Hunter Water Corporation
ABN 46 228 513 446

Hunter Water Ref: HW2017-1215/18/104

**RE: ADVICE ON RESPONSE TO SUBMISSIONS AND AMENDMENT REPORT -
HUNTER INDOOR SPORTS CENTRE (SSD-65595459)**

DRAWING TITLE
GENERAL ARRANGEMENT PLAN

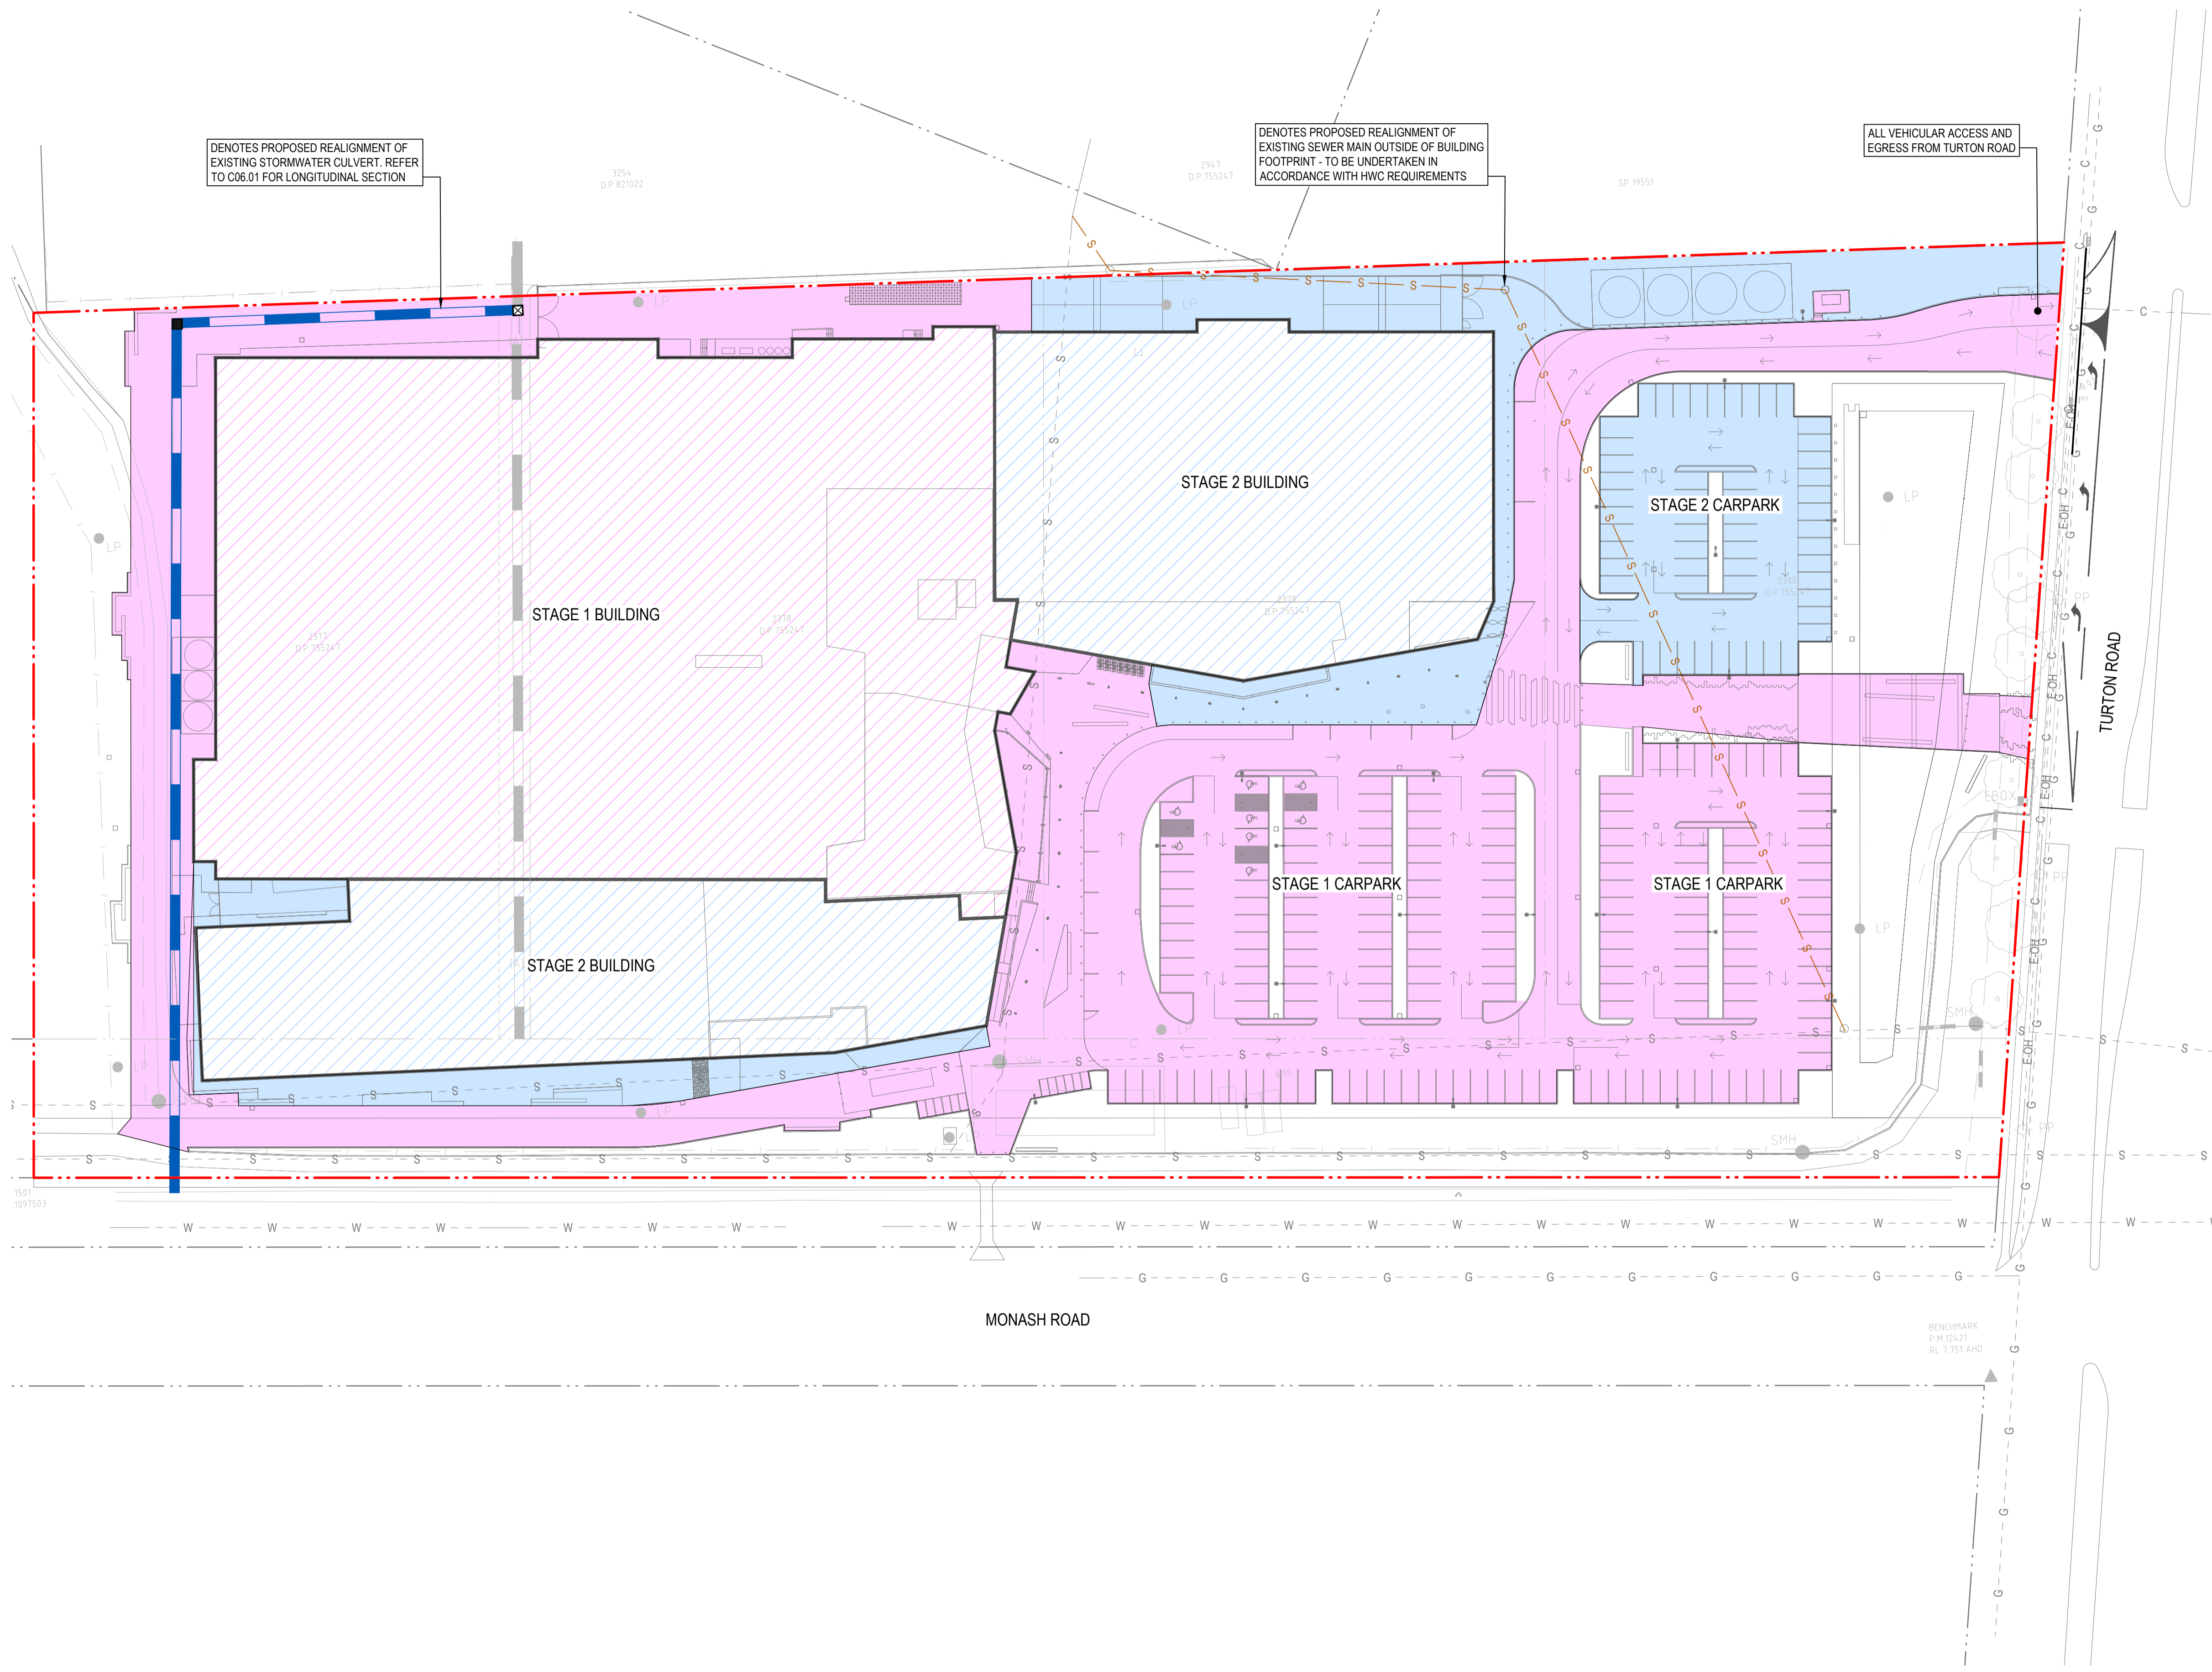
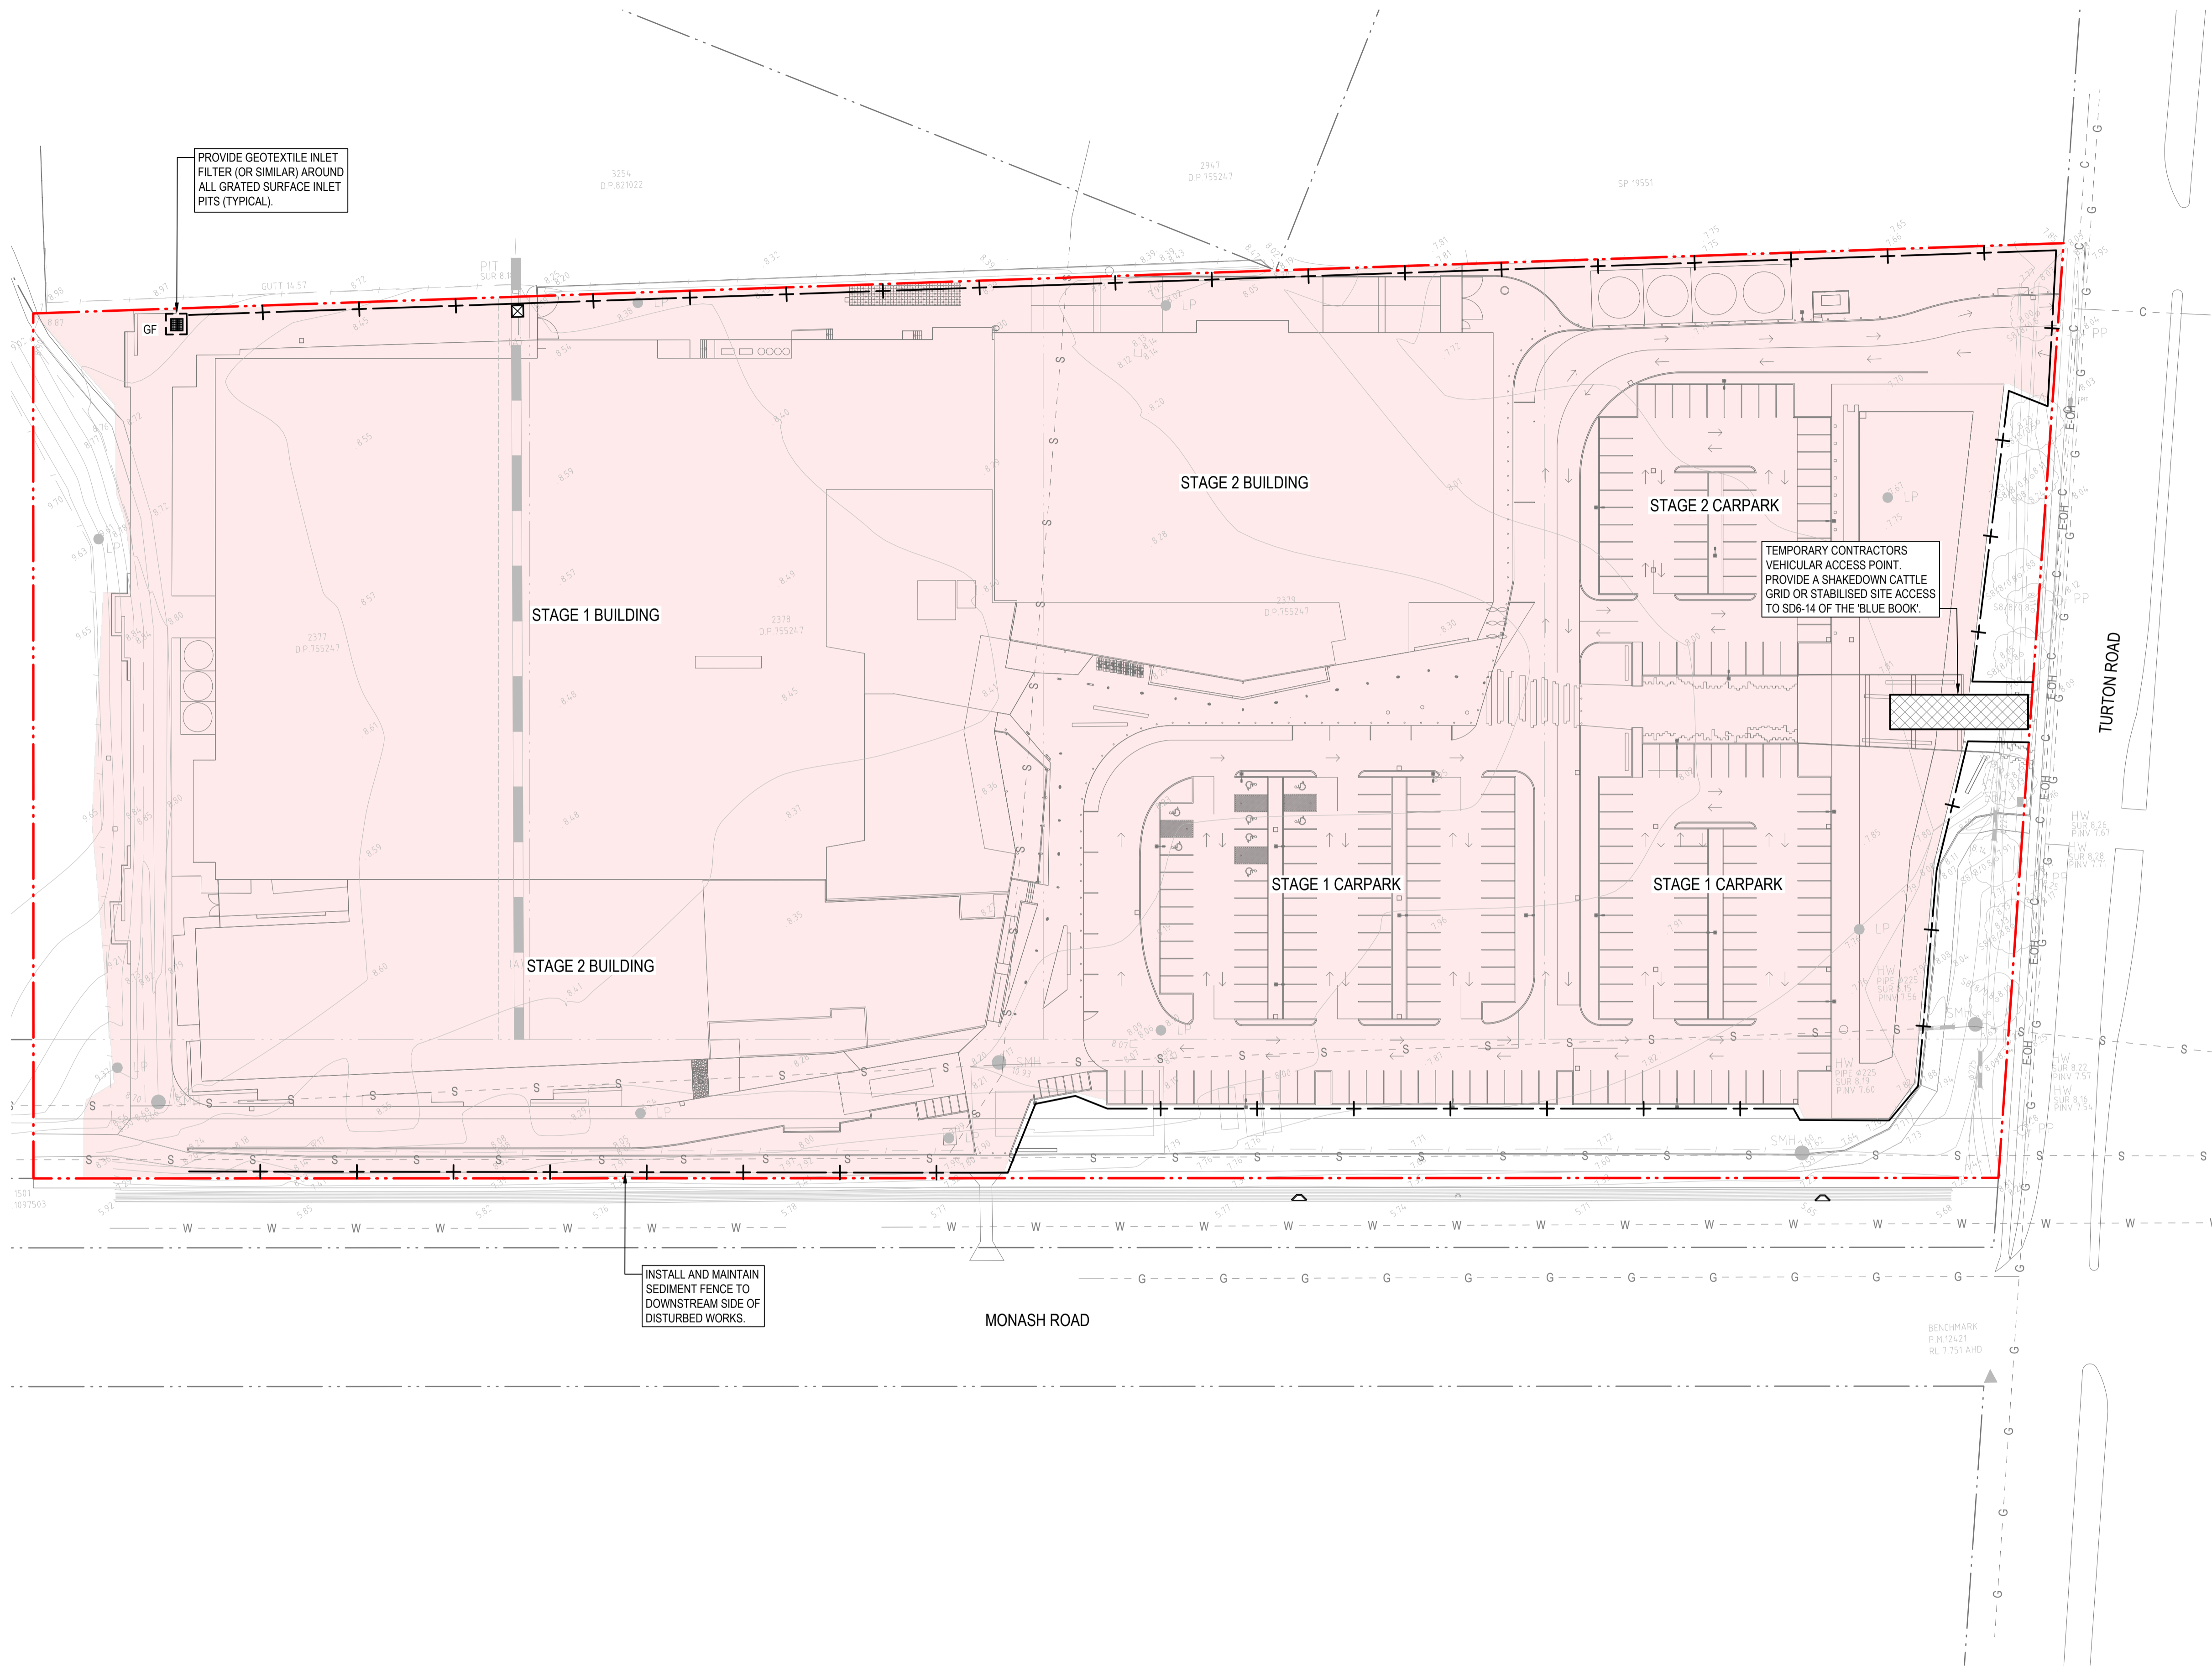
Hunter Water notes that the building footprint has moved 19.5m to the west under the revised development plans, with the *RTS and Amendment Report* indicating that:

"the existing Hunter Water stormwater culvert that runs north to south across the site ... will be realigned around the amended development footprint."

The *Concept Soil and Water Management Plan* (Appendix Q) prepared by Groundswell Engineers advises that the grade of the realigned culvert is generally maintained and allows for the culvert to still discharge to the existing stormwater channel. Hunter Water has not received a Request for Information relating to the Work as Constructed drawings for this culvert, and we therefore assume:

- A site inspection and/or survey of the asset has been undertaken; or
- The assumptions relating to the location and levels of the existing culvert will remain valid throughout the design and construction of the culvert realignment.

Hunter Water will not permit the existing culvert to remain in its current location and the development to build over it. It is critical that the proponent ensures that the realignment of this stormwater culvert around the amended development footprint is technically feasible.
